**PROPOSED MULTI FUNCTION HALL SPACE AND ASSOCIATED
ACCOMMODATION
AYSCOUGH FEE HALL SCHOOL - SPALDING
PLANNING REF: H16/1339/01**

Following receipt of the approval notices for the above scheme, we now enclose for your review copies of our amended elevations indicating the following revisions, outlined in the approval conditions.

Amended elevations

Dwg. Nos. 01.015/18A; /19A; /20A & /38

TITLE
Part Elevation and Section
South East Elevation

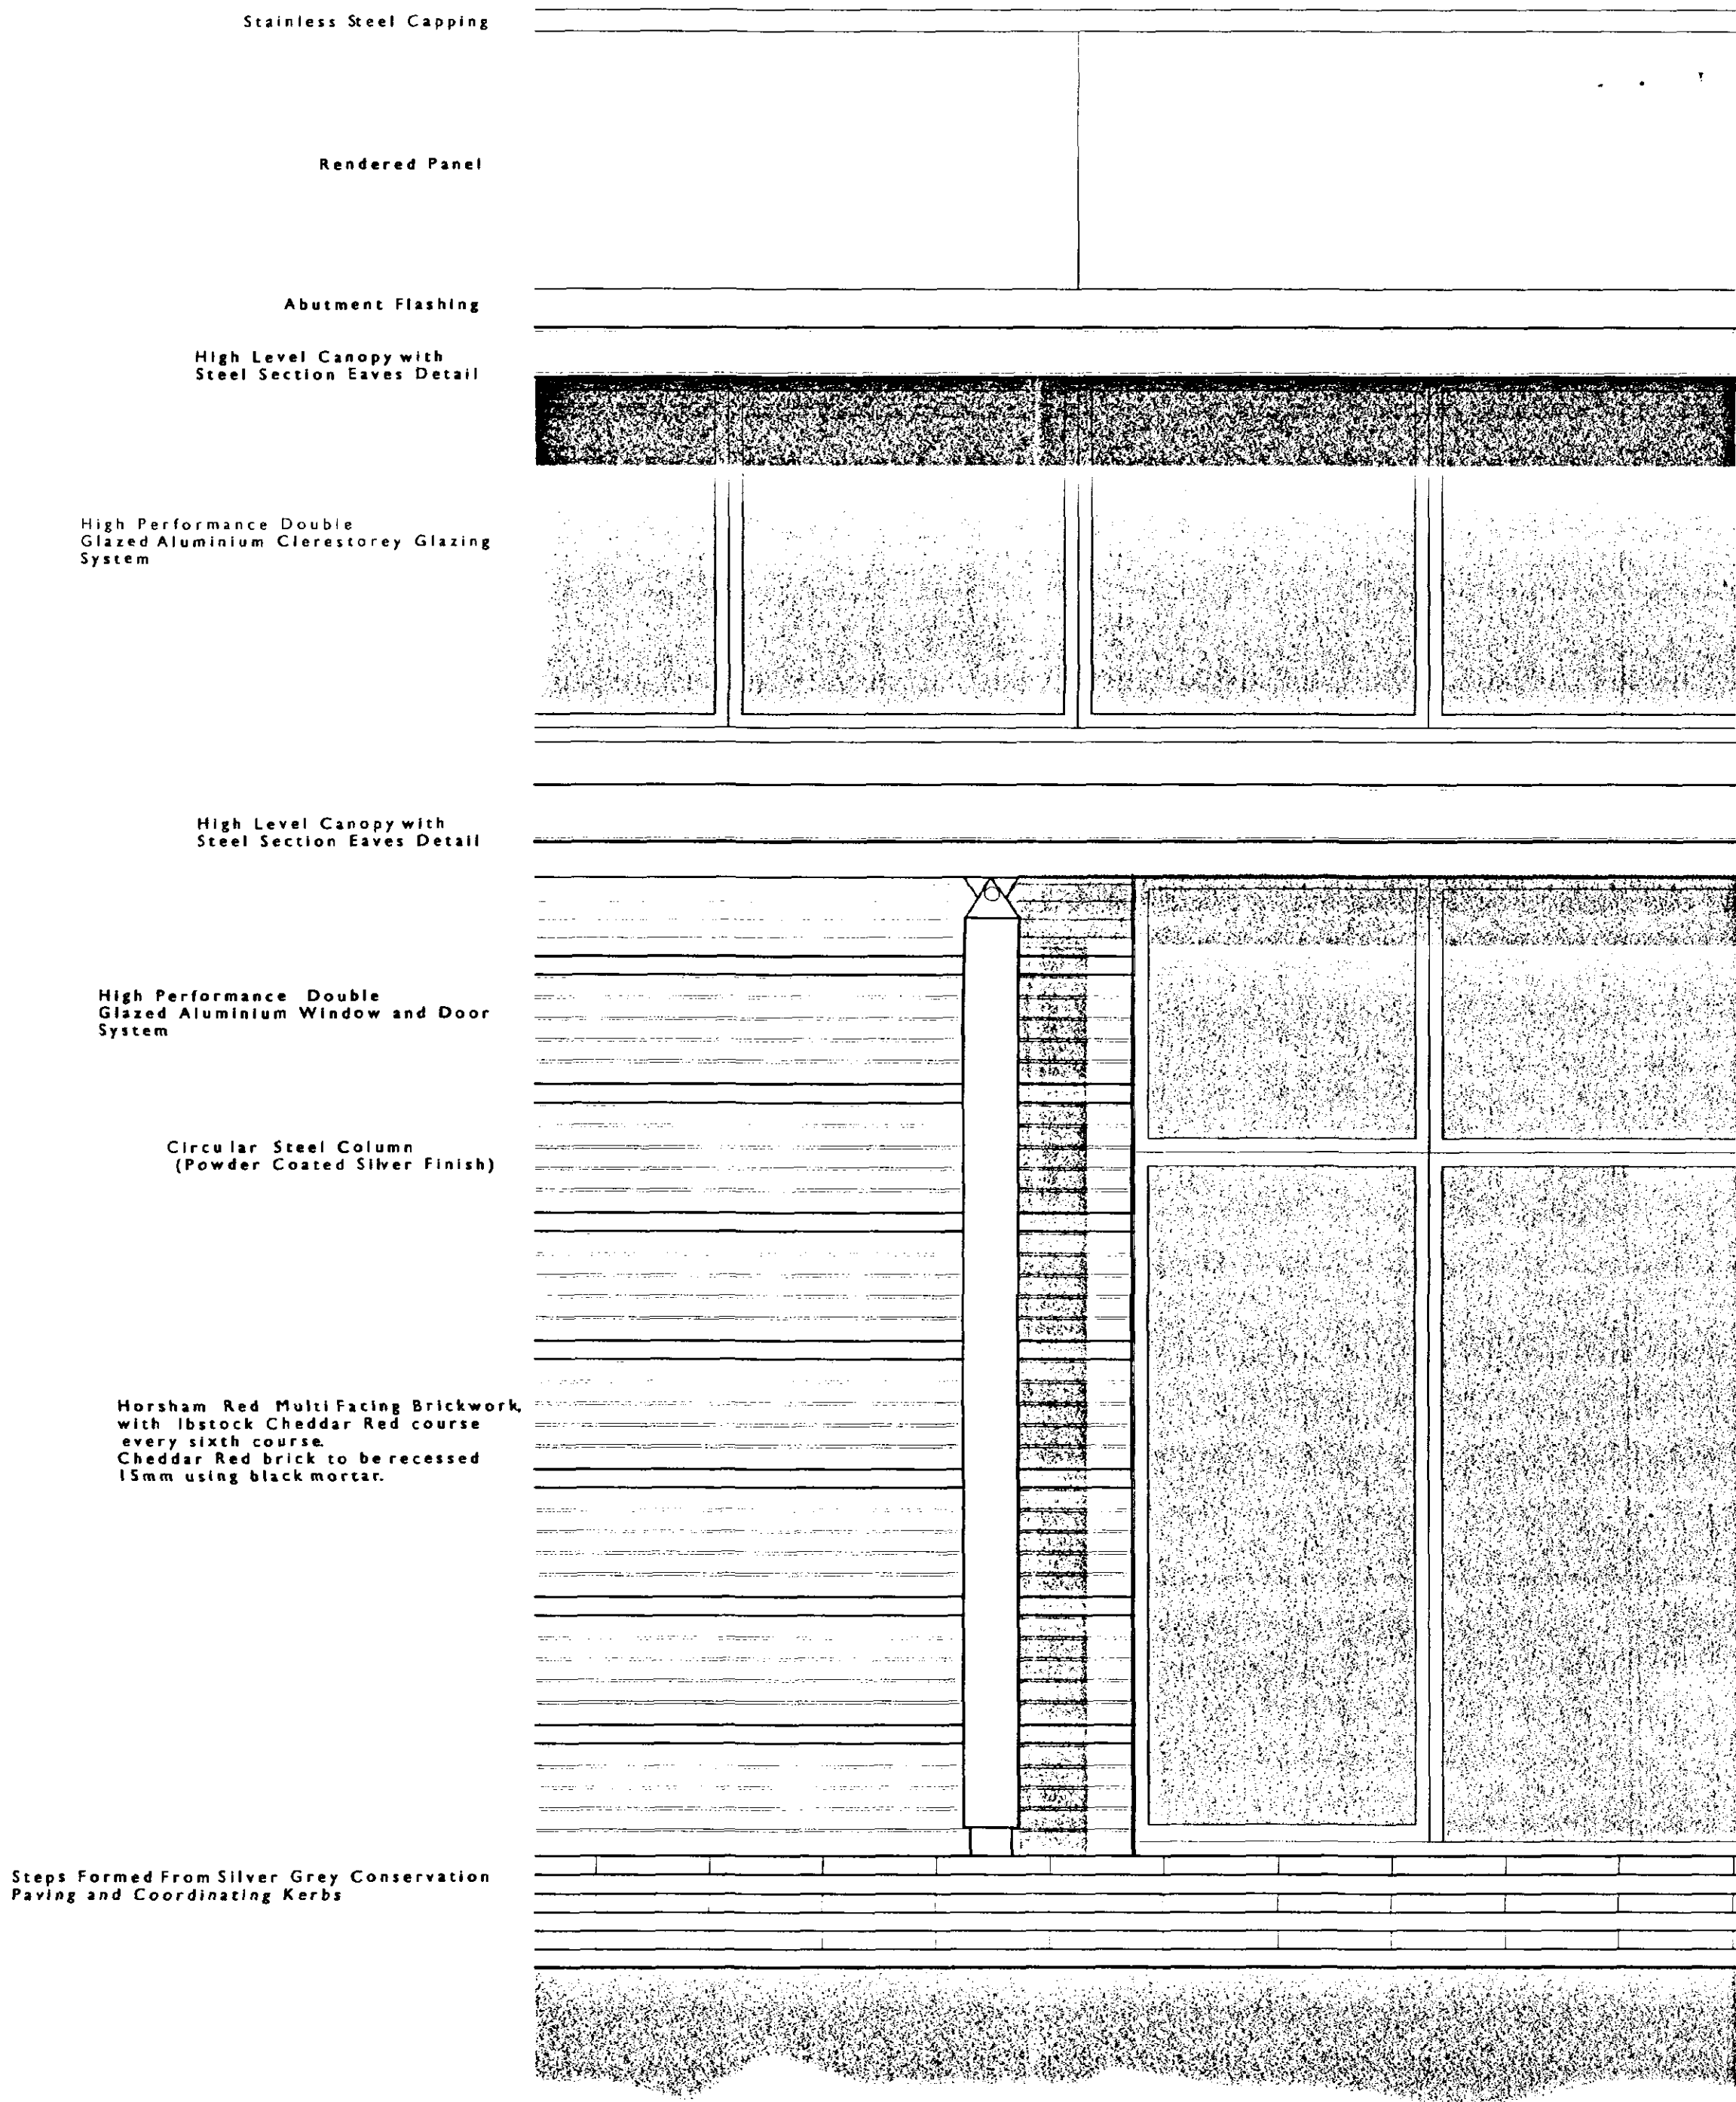
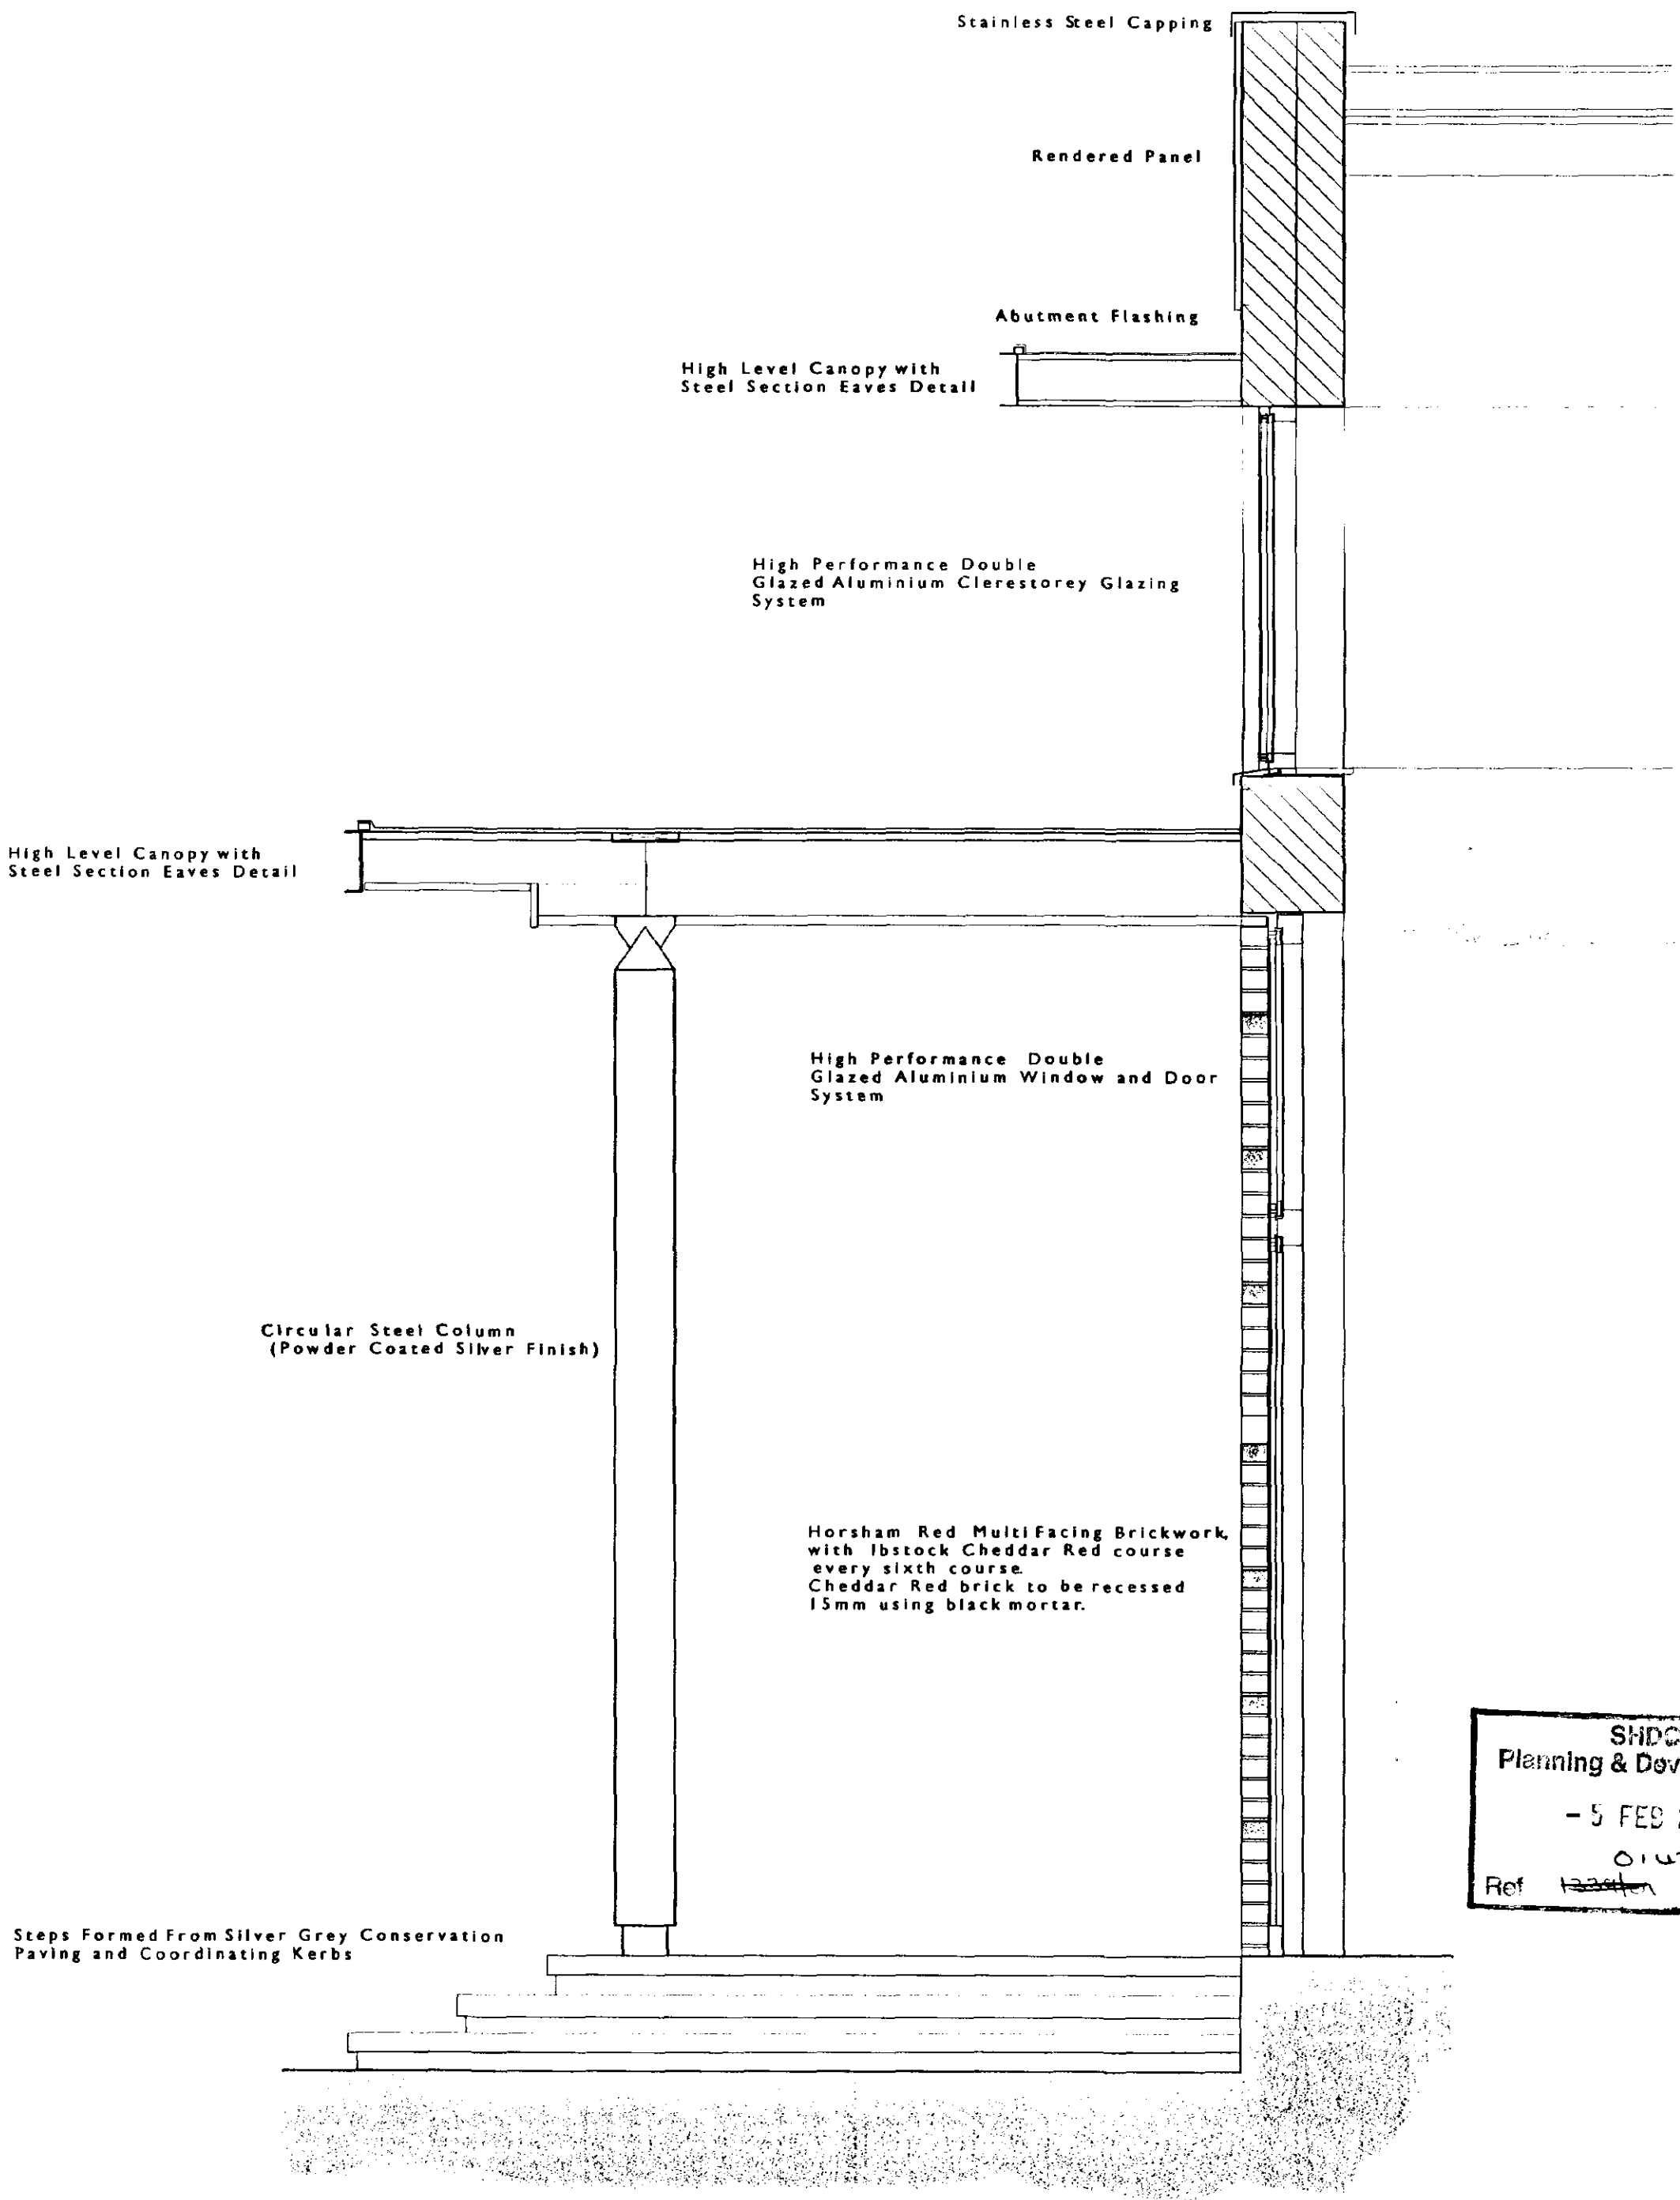
- i. The high level cedar boarding, previously noted on the elevations has been omitted, in favour of a insulated rendered panel. We propose to use the Rockwook Rockshield system, which can be impregnated with various colour pigments (see enclosed literature). Boarded panels have also been omitted as an infill to the glazing system.
- ii. As outline in our correspondence dated 9 January 2003, we also propose to omit the contrasting string course detailed previously in our drawing 01.015.20 (part elevation). This has been amended to a matching red lacy brick (IB stock cheddar red) recessed 15mm, in order to make visual reference to the existing banding detail, to the North East elevation of Welland Hall house.
